Substantive response of the Local Highway Authority to a planning consultation received under The Development Management Order.

Planning Application Number: 23/1004/DOC

Application Address: Trent Pottery Co Regent Street Narborough Leicestershire LE19 2DJ

Description of Application: Re-consultation. Discharge of conditions No. 4 (Lighting and CCTV), 5. (Cycle Parking), 8. (Construction Method Statement) and 12. (Landscaping Scheme) in relation to permission 23/0385/FUL.

| DRAWING TITLE: PROPOSED CYCLE PARKING | | | | | |

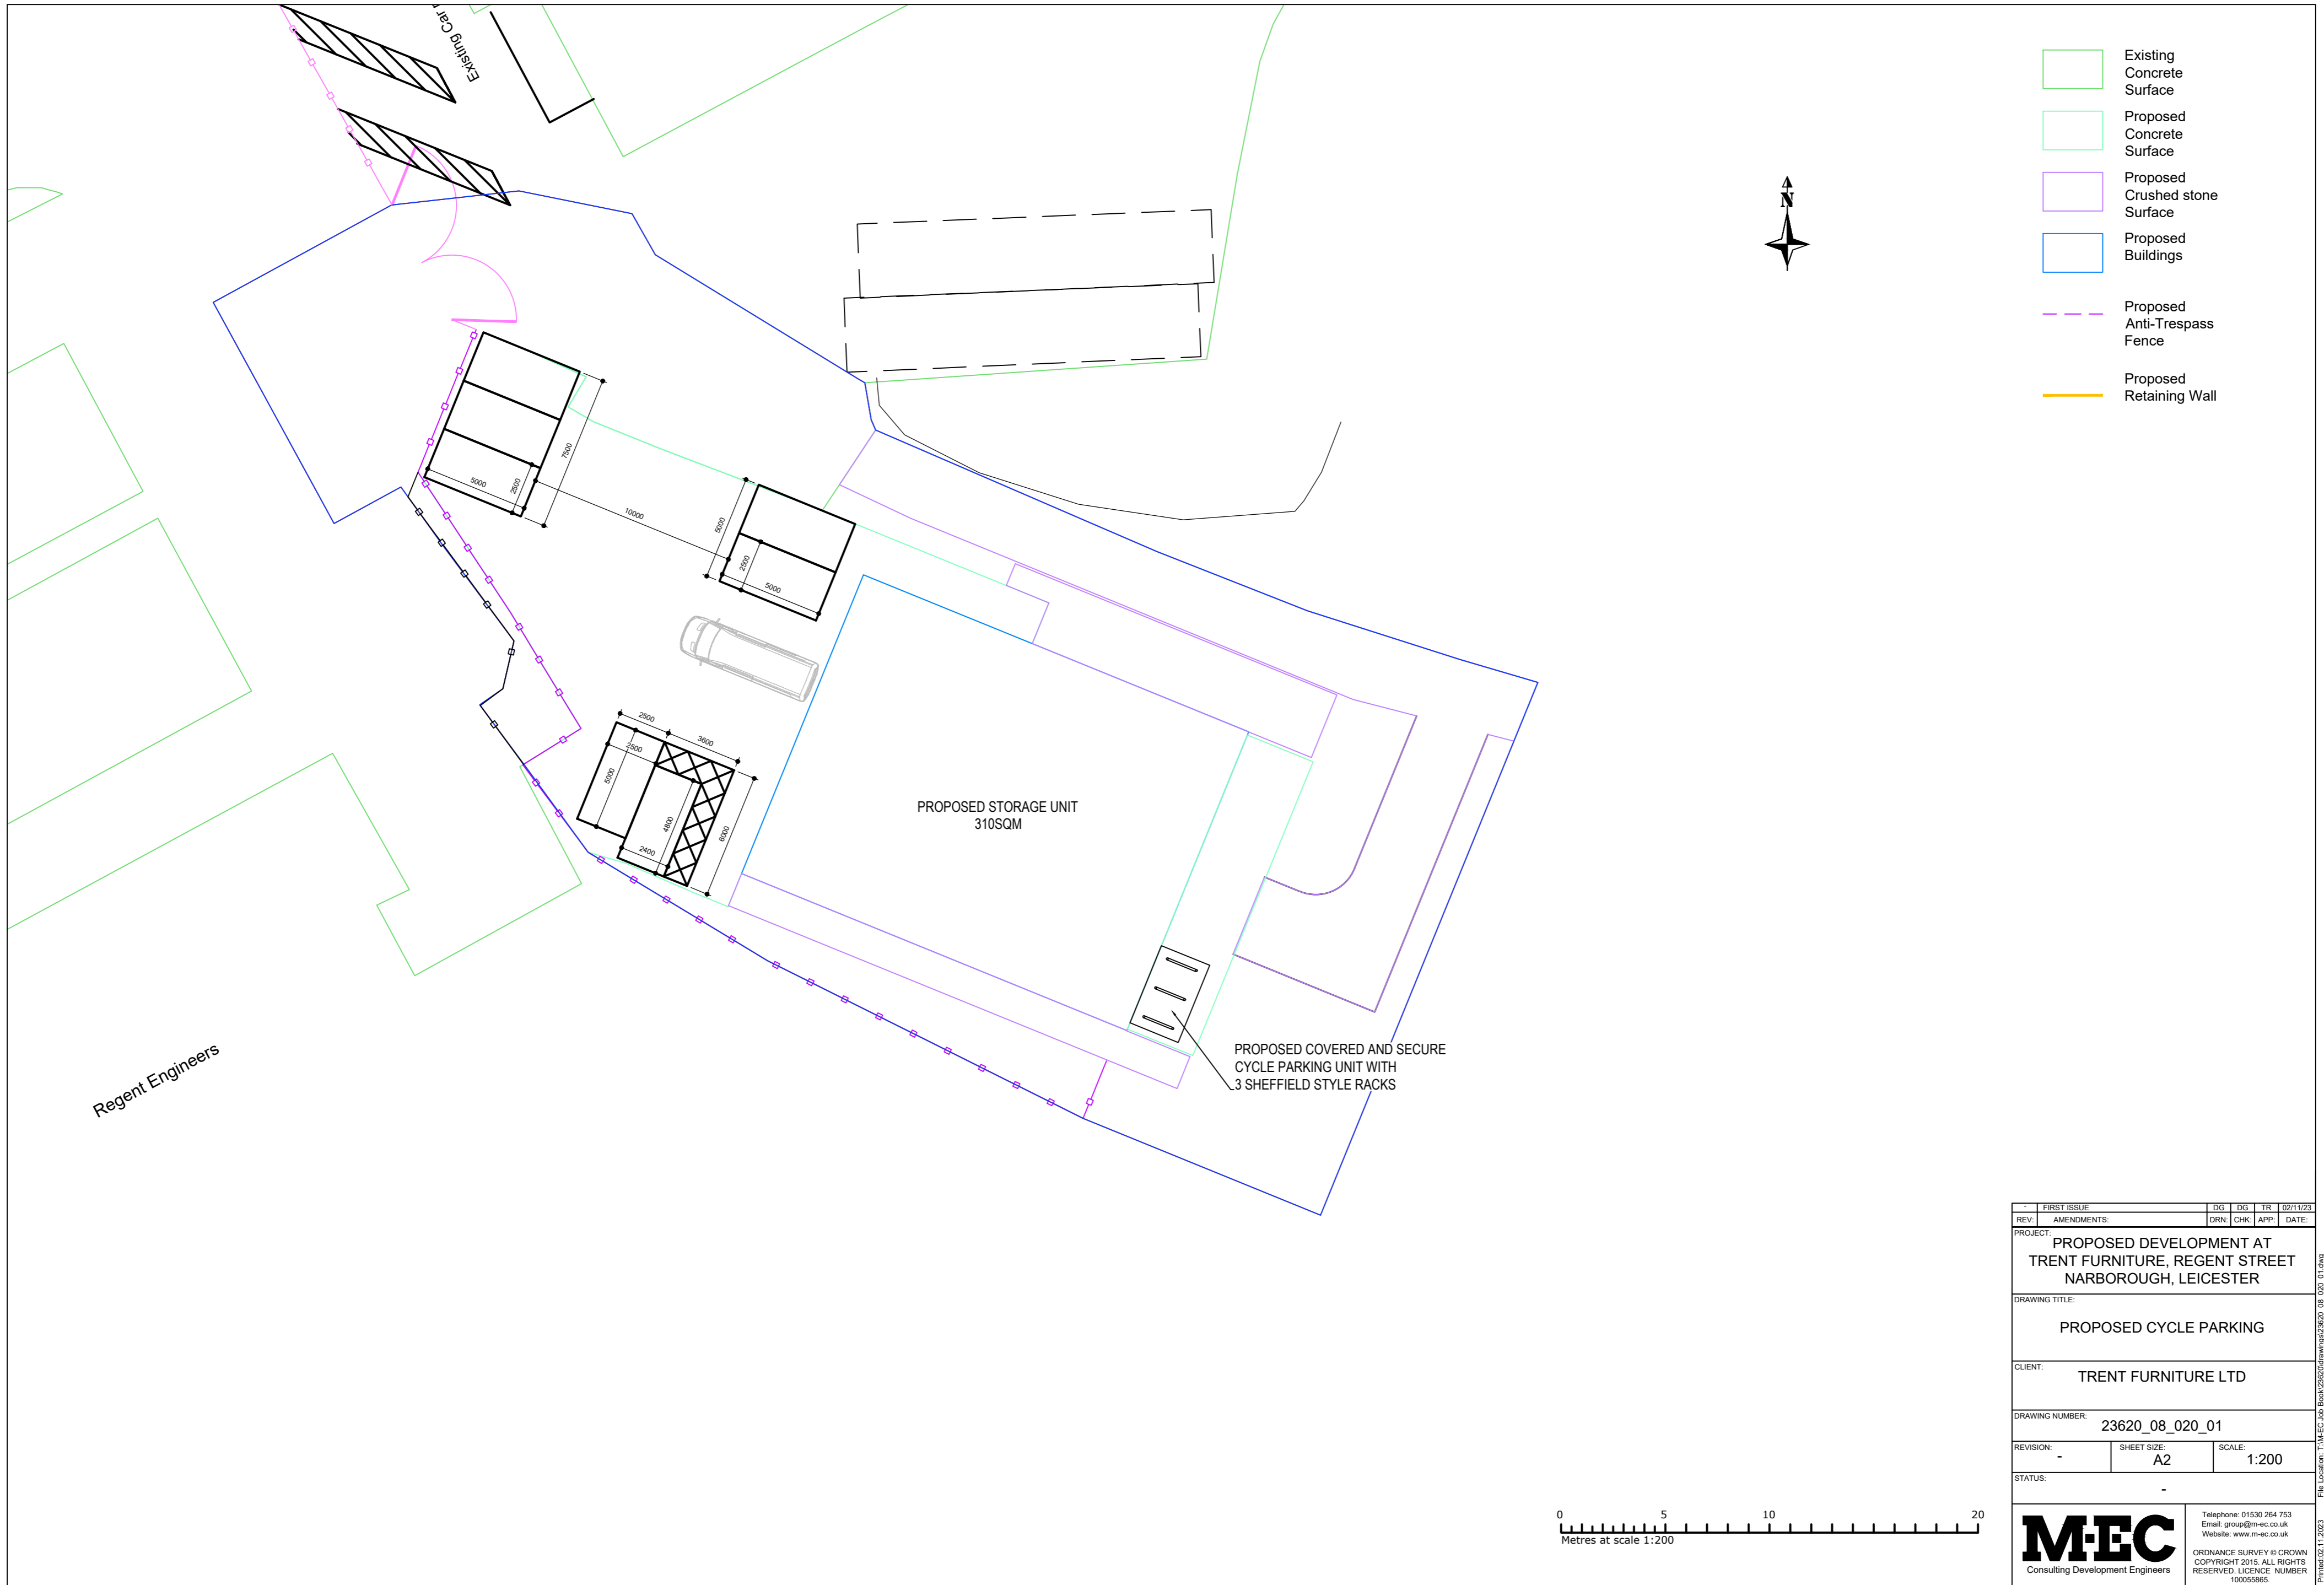
The 'Proposed Cycle Parking' drawing (MEC, drawing number 23620_08_020_01) shows a Bike Cycle Shelter shown on site. As per 3.179 of the Leicestershire Highways Design Guide (LHDG) - all cycle parking should be secure and normally with weather protection provided at least for employee parking. The LHDG also recommends Sheffield Stands as illustrated by DG16 of the LHDG.

The applicant has demonstrated the cycle shelter will be covered, secure and consist of Sheffield Stands. The LHA have reviewed further information submitted by the Local Planning Authority (LPA) and based on the provision that staff use the rear door rather than the ground floor access, the LHA are satisfied for condition 5 to be discharged.
